January 10, 2020

**SUBJECT: Monument Academy – Site Development Plan
Response to County Planning Review Comments
PPR-19-009**

This letter provides responses to the remaining review comments detailed in the PCD Project Manager Comments posted on EDARP on 9/11/19. These review comments are specifically addressed as follows **(Applicant responses are annotated in bold / blue / parenthesis following each County comment):**

C1.1

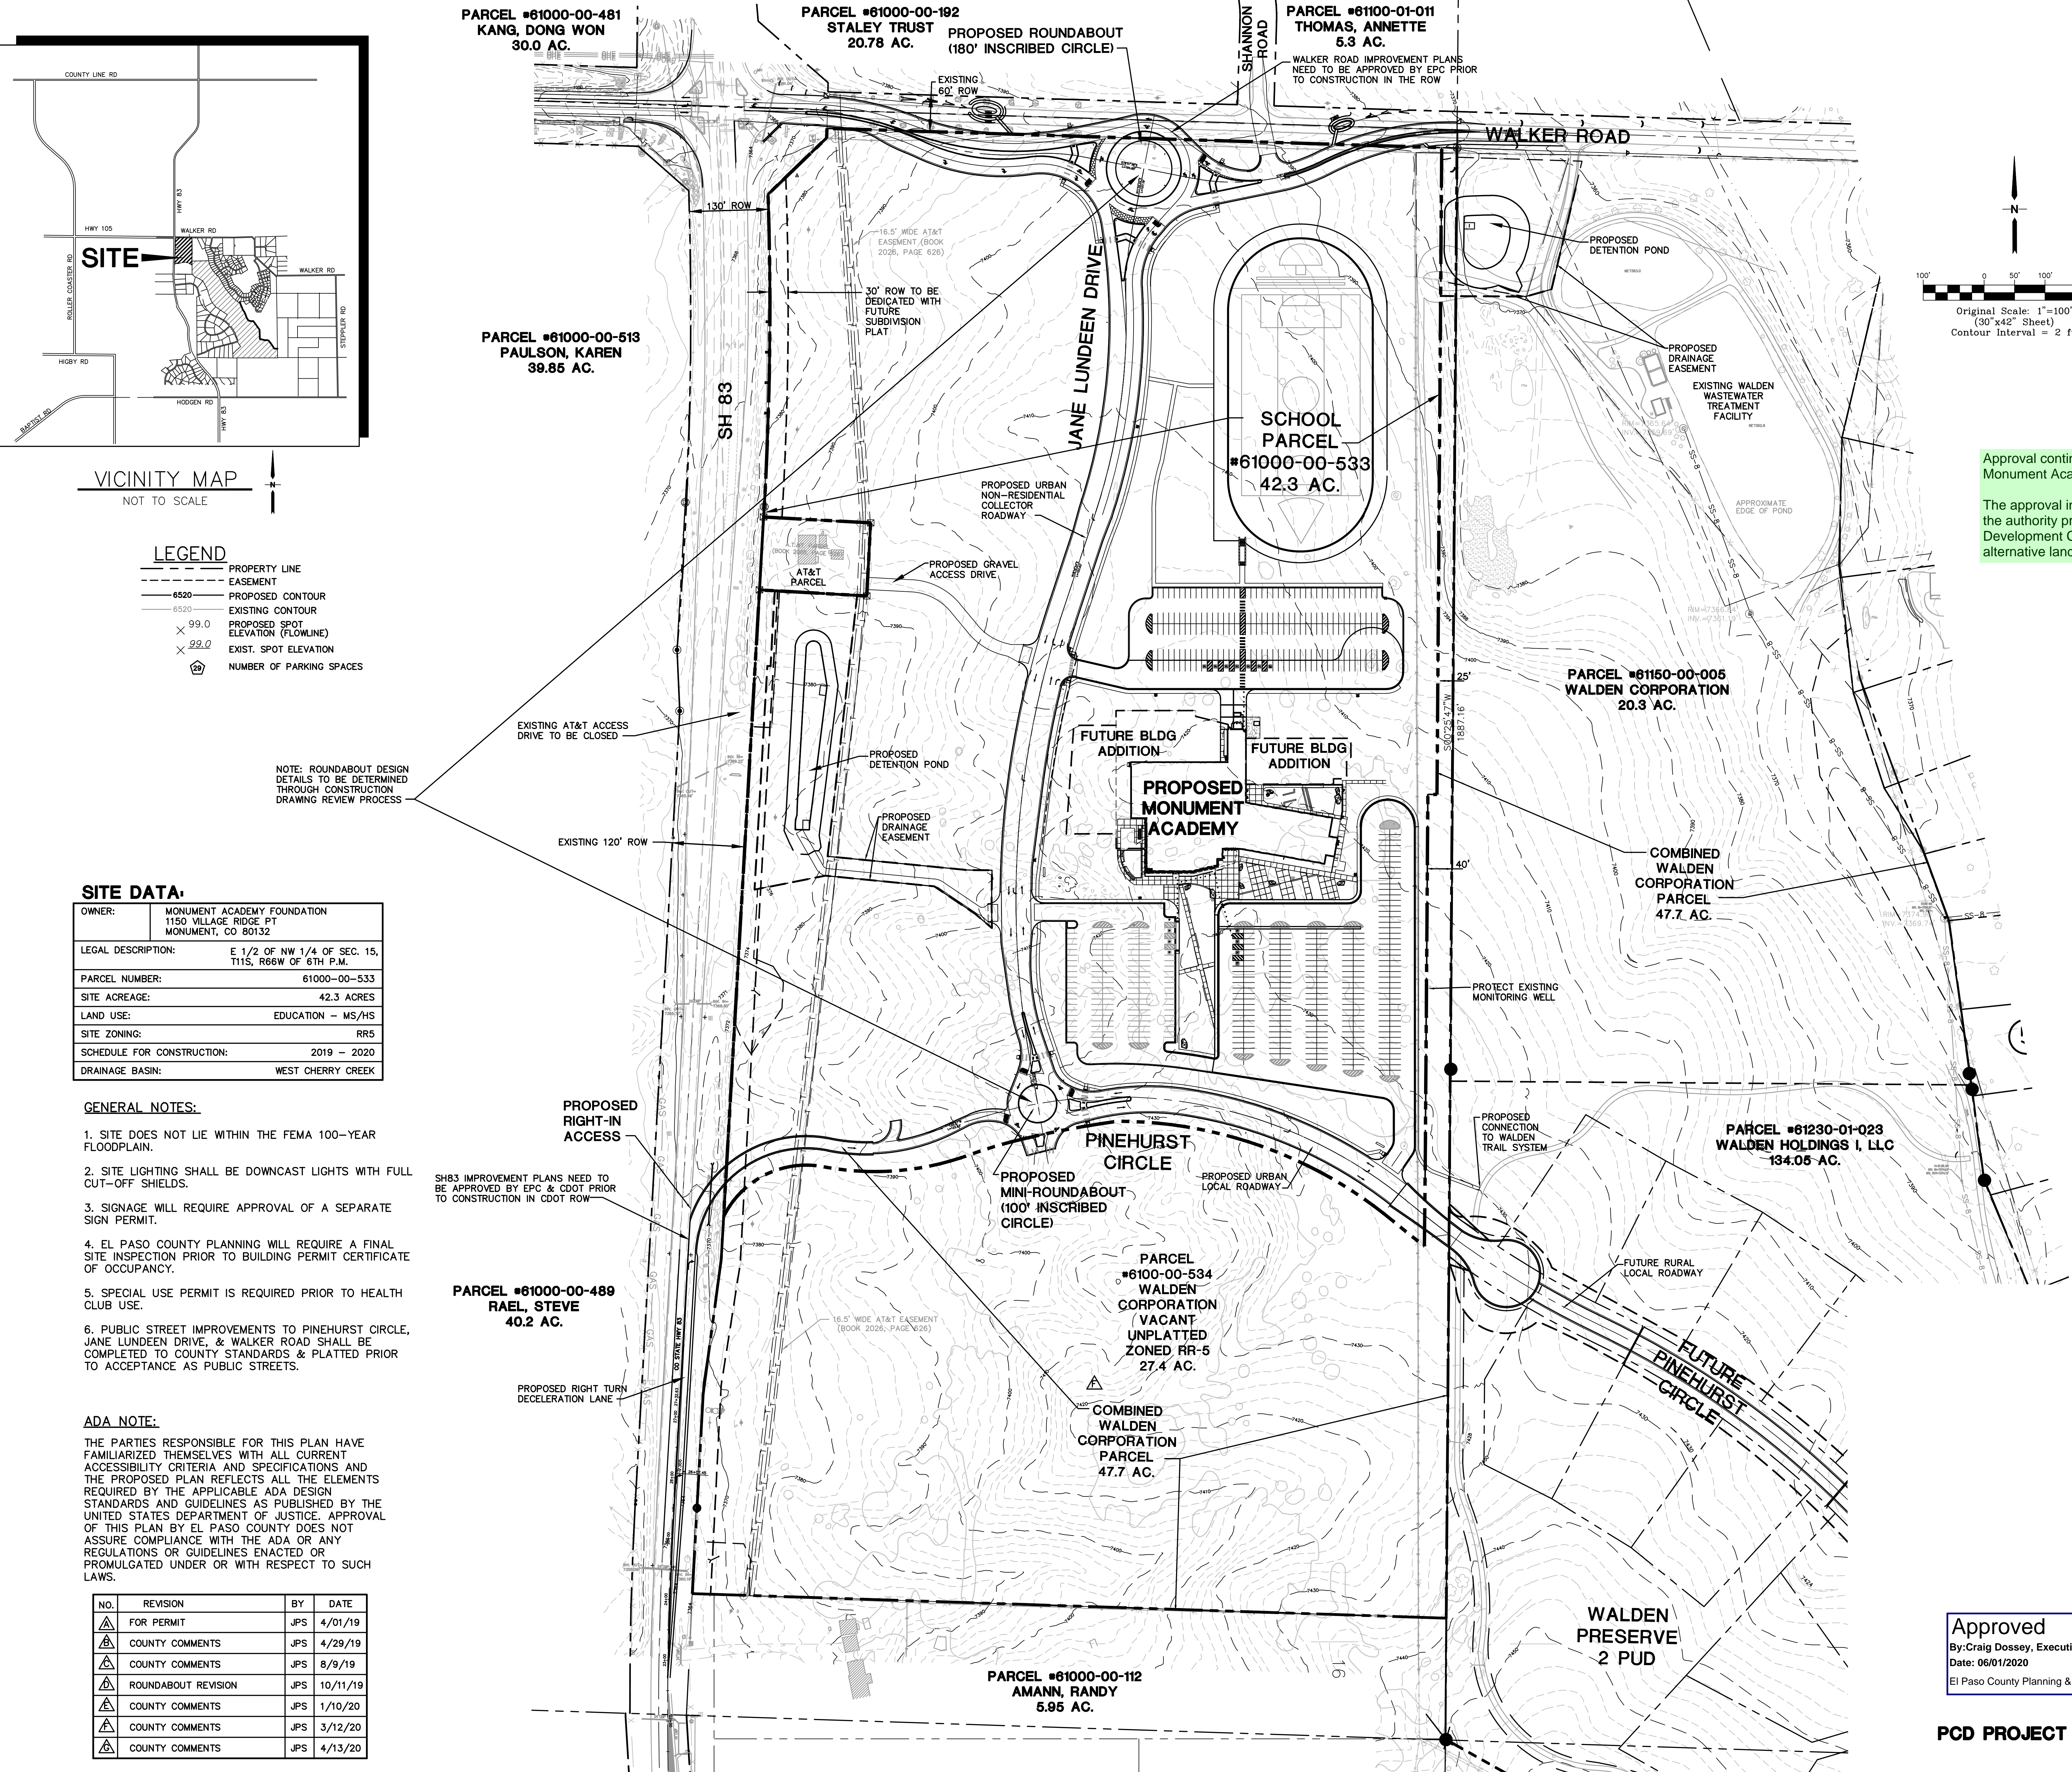
NOTE: the ownership does not reflect the ownership shown in the assessor records. The ownership on all documents will need to reflect what is in place at the time of site development plan approval. **(Parcel numbers on Sh. C1.1-C1.2 have been updated to reflect the parcel numbers currently shown on the Assessor’s web site.)**

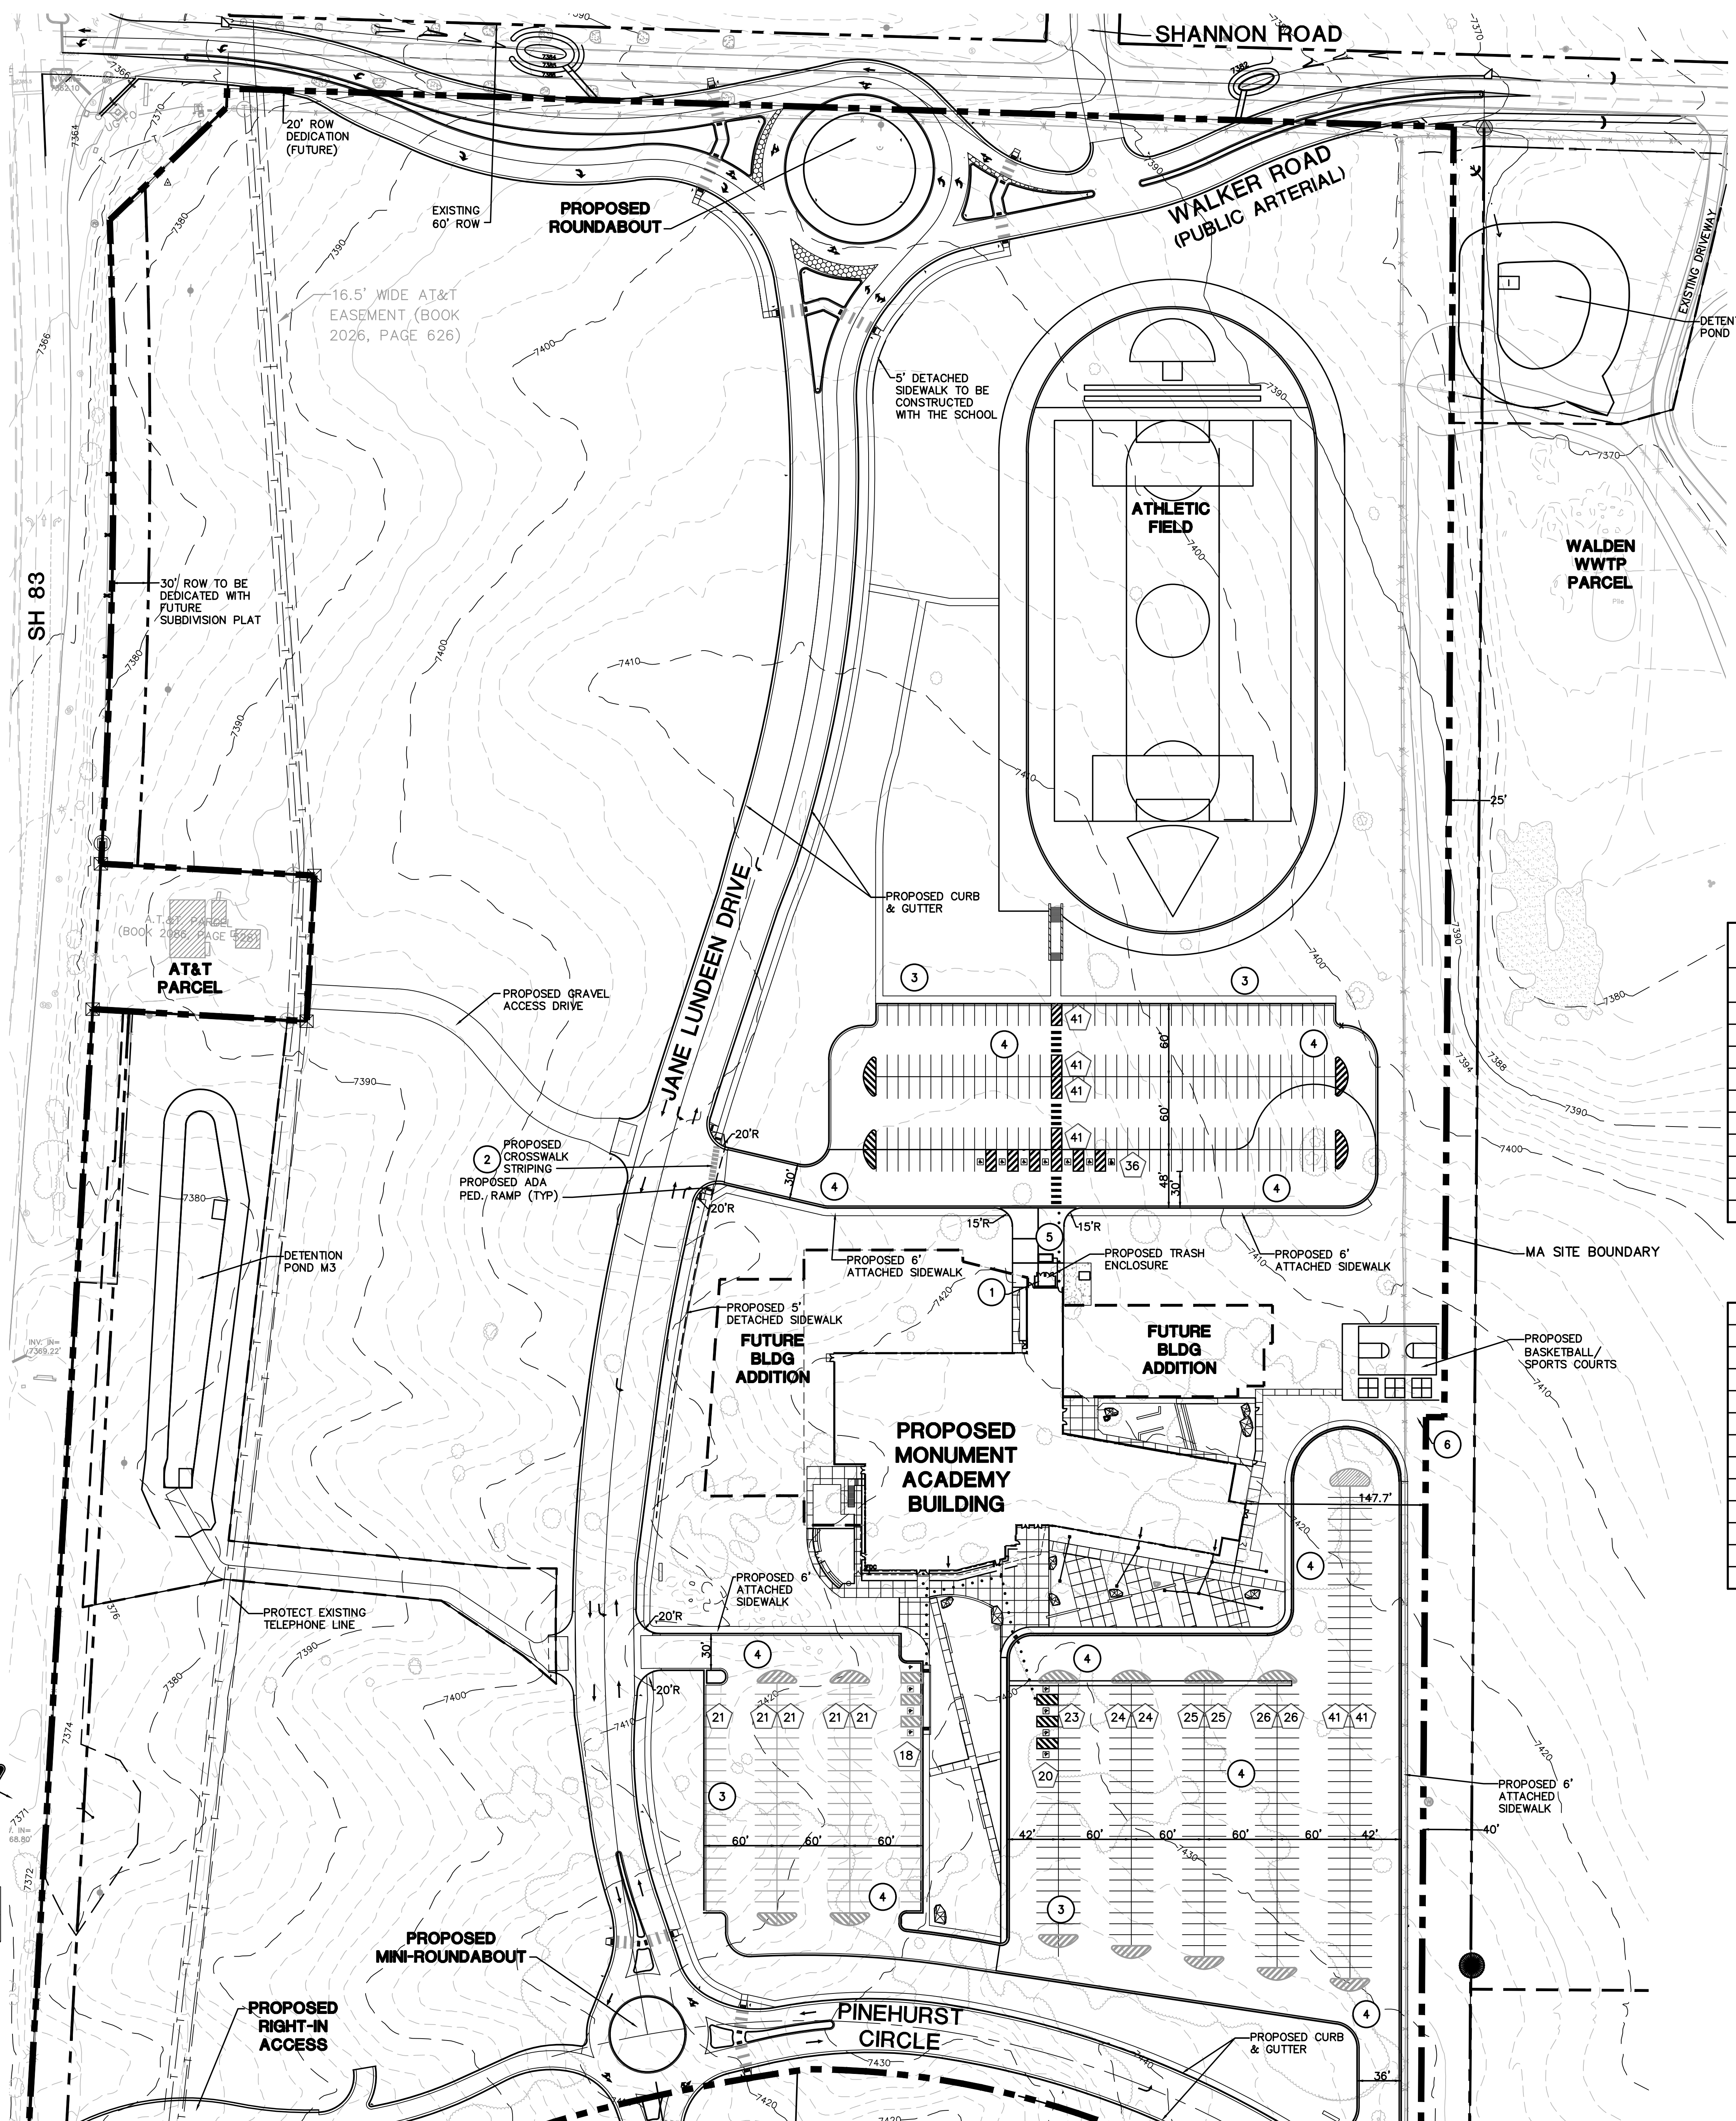
2. Please specify on the floorplan which rooms are middle vs high school classrooms so we can verify parking ratios. **(As requested, the floorplans have been annotated to identify the anticipated middle vs. high school classroom designations. As shown in the parking data table on Sh. C1.2, the total number of parking spaces provided far exceeds the minimum spaces required by the LDC).**
